KENT DOWNS AONB UNIT - Unique Ref 20035310

WRITTEN REPRESENTATION

**Detailed comments on the Assessment of Effects reported in Chapter 7 of the Environmental statement (LVIA)
on receptors pertinent to the
Kent Downs AONB.**

*Local Landscape Character Area boundaries of the Kent Downs AONB LCA, West Kent Downs, Sub-areas Cobham and Shorne*

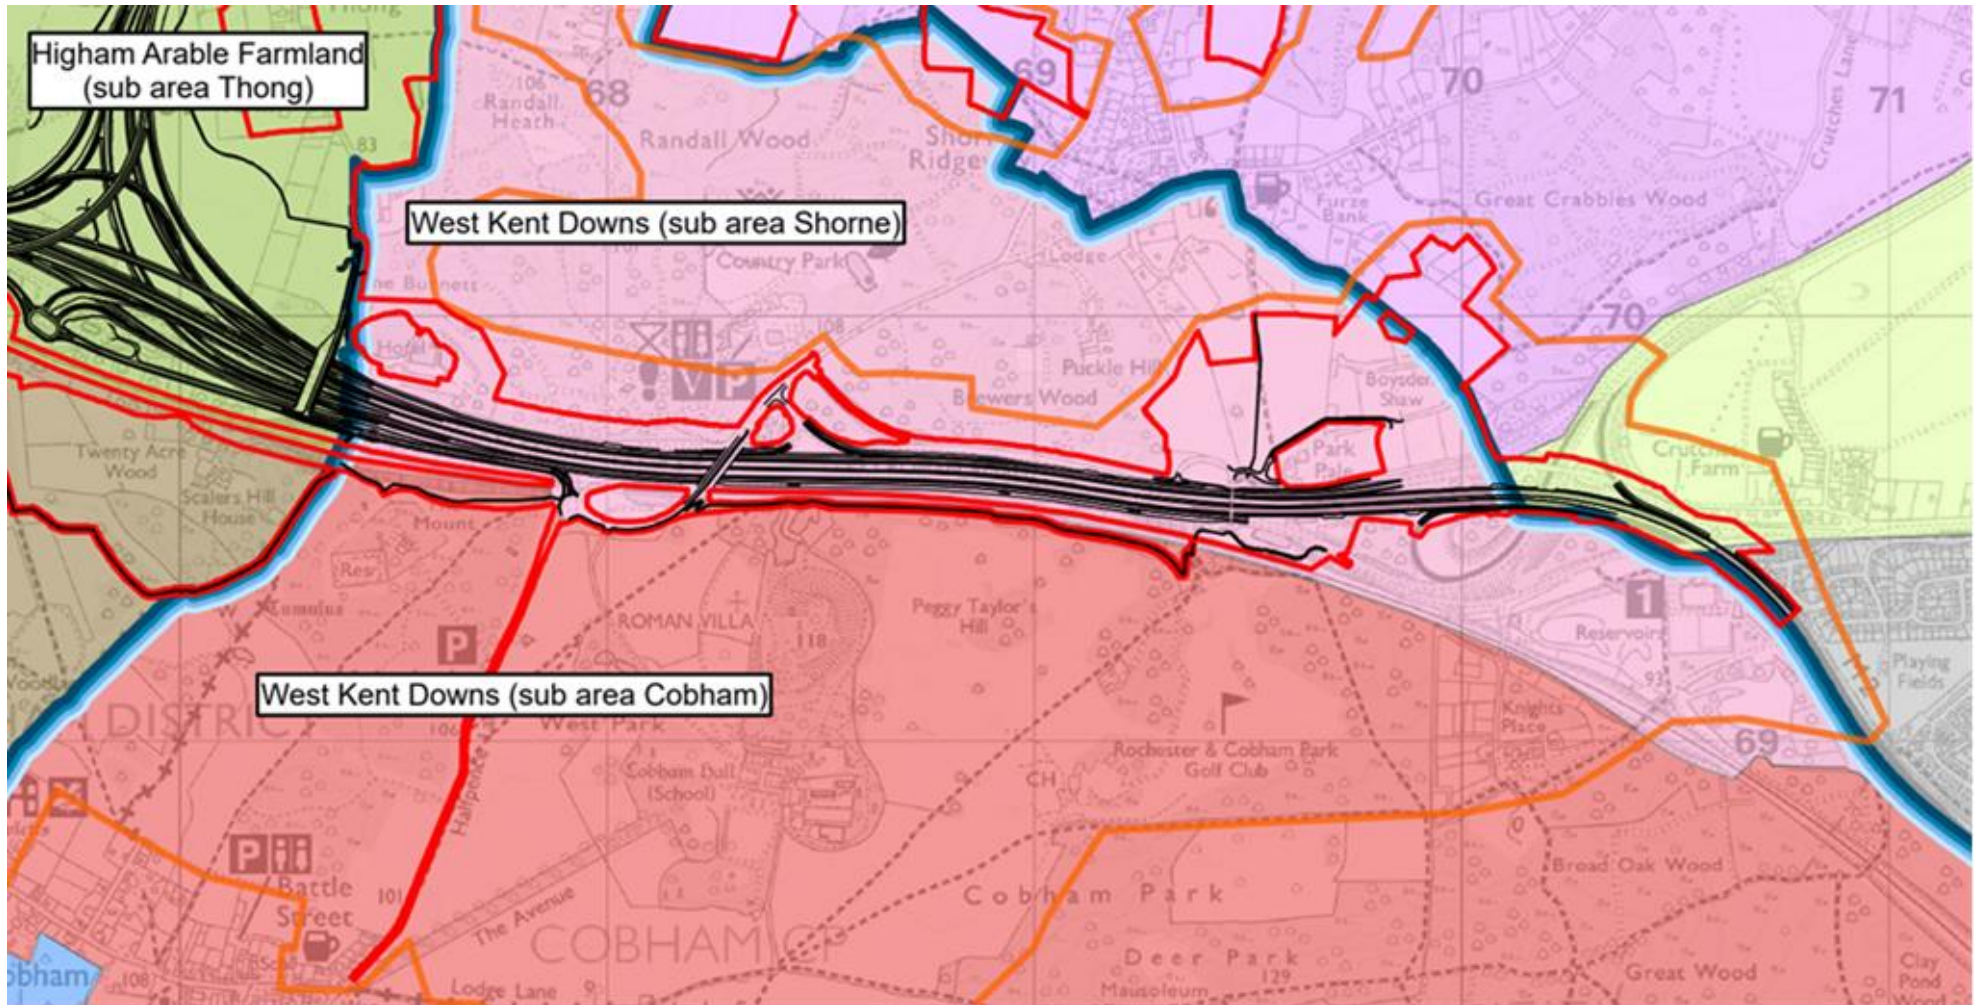
LCA's WITHIN THE AONB					
Landscape Receptor	Sensitivity	Magnitude of Effect & Significance (Construction)	Magnitude of Effect & Significance (Opening Year)	Magnitude of Effect & Significance (Design Year)	Kent Downs AONB Unit Commentary
West Kent Downs (Sub area Shorne)	Very High <i>(2020 Very High)</i>	Major adverse = Very Large adverse effect <i>(2020 Major adverse = Very Large adverse effect)</i>	Moderate adverse = Large adverse effect <i>(2020 Moderate adverse = Large adverse effect)</i>	Minor adverse = Moderate adverse effect <i>(2020 Moderate adverse = Large adverse effect)</i>	Agree Sensitivity is Very High. Main impacts are identified as being the modified and widened transport corridor, new earth works and retaining structures, absence of vegetation, greater severance of the landscape, plus beneficial AW compensation and nitrogen deposition sites. Significance of effect is assessed as large rather than very large 'due to the localised nature of effects' – however the effects extend to over 2 km in length within this LCA. It is recognised that there would be a permanent reduction in tranquillity and while some planting lost would be replaced, there would continue to be a permanent increase in the prominence and scale of the A2 corridor.

<p>Agree that there would be a Very Large Adverse Magnitude of effect at Construction but consider a Moderate Adverse effect would remain at Design Year given the permanent and extensive nature of the effects on key aspects of this LCA. This would align with the 2020 assessment.</p> <p>With a Very High sensitivity and moderate adverse effect this equates to a large adverse and significant residual effect.</p>
West Kent Downs (Sub area Cobham)	High <i>(2020 Very High)</i>	Minor adverse = Moderate adverse <i>(2020 Moderate adverse = Large adverse effect)</i>	Negligible adverse = Slight adverse effect <i>(2020 Moderate adverse = Large adverse effect)</i>	Negligible adverse = Slight adverse effect <i>(2020 Minor adverse = Moderate adverse effect)</i>	<p>Consider that Sensitivity should be Very High, rather than High as per the 2020 Assessment. The LVIA states the presence of the A2 results in some ability to accommodate the Project without substantial loss of overall integrity, giving it a Medium degree of susceptibility to specific change, but this justification isn't applied to the Sub Area of Shorne (see above) in which the actual transport corridor lies.</p> <p>It is advised that impacts would be largely limited to a small part of this LCA and largely be confined to creation of NCN route along public right of way. But it would also involve the loss of HS1 mitigation planting and the wooded central reservation, as well as greater severance of the AONB landscape along with the widened transport corridor and associated infrastructure such as retaining walls, gantries etc.</p> <p>Therefore strongly disagree that Magnitude of effect would be Minor at Construction and Negligible at Opening Year and Design Year which are much reduced effects from the 2020 version. Consider a more realistic assessment would be a Moderate adverse effect at Construction, Year 1 and Year 15.</p> <p>With a Very High sensitivity and moderate adverse effect, this equates to a large adverse and therefore significant residual effect.</p>

West Kent Downs (overview for Sub areas)	Very High <i>(2020 Very High)</i>	Moderate adverse = Large adverse effect	Moderate adverse = Large adverse effect	Minor adverse = Moderate adverse effect	<p>Agree with the assigned Very High Sensitivity.</p> <p>With regards to impacts on the AONB's special character, agree there would be minimal impact on dramatic landform and views, and farmed character. There would however be impacts on woodland and trees and on the special</p>

Shorne and Cobham)		<i>(2020 Moderate adverse = Large adverse effect)</i>	<i>(2020 Moderate adverse = Large adverse effect)</i>	<i>(2020 Moderate adverse = Large adverse effect)</i>	<p>quality of biodiversity rich habitats due to much of this area comprising Ancient Woodland and SSSI. While compensation planting is proposed, this will take years to provide the same level of benefit as that which would be lost and much of which is proposed outside of this LCA. There would also be a reduction in tranquillity as noted in the Assessment.</p> <p>The Significance of effect is assessed as large rather than very large ‘due to the localised nature of effects’ – however the effects extend to over 2 km in length within this LCA.</p> <p>Therefore, while it is agreed that there would be a Very Large Adverse effect at Construction, it is considered that a Moderate Adverse effect would remain at Design Year, as concluded in the 2020 assessment.</p> <p>With a Very High sensitivity and moderate adverse effect, this equates to a large adverse and therefore significant residual effect.</p>
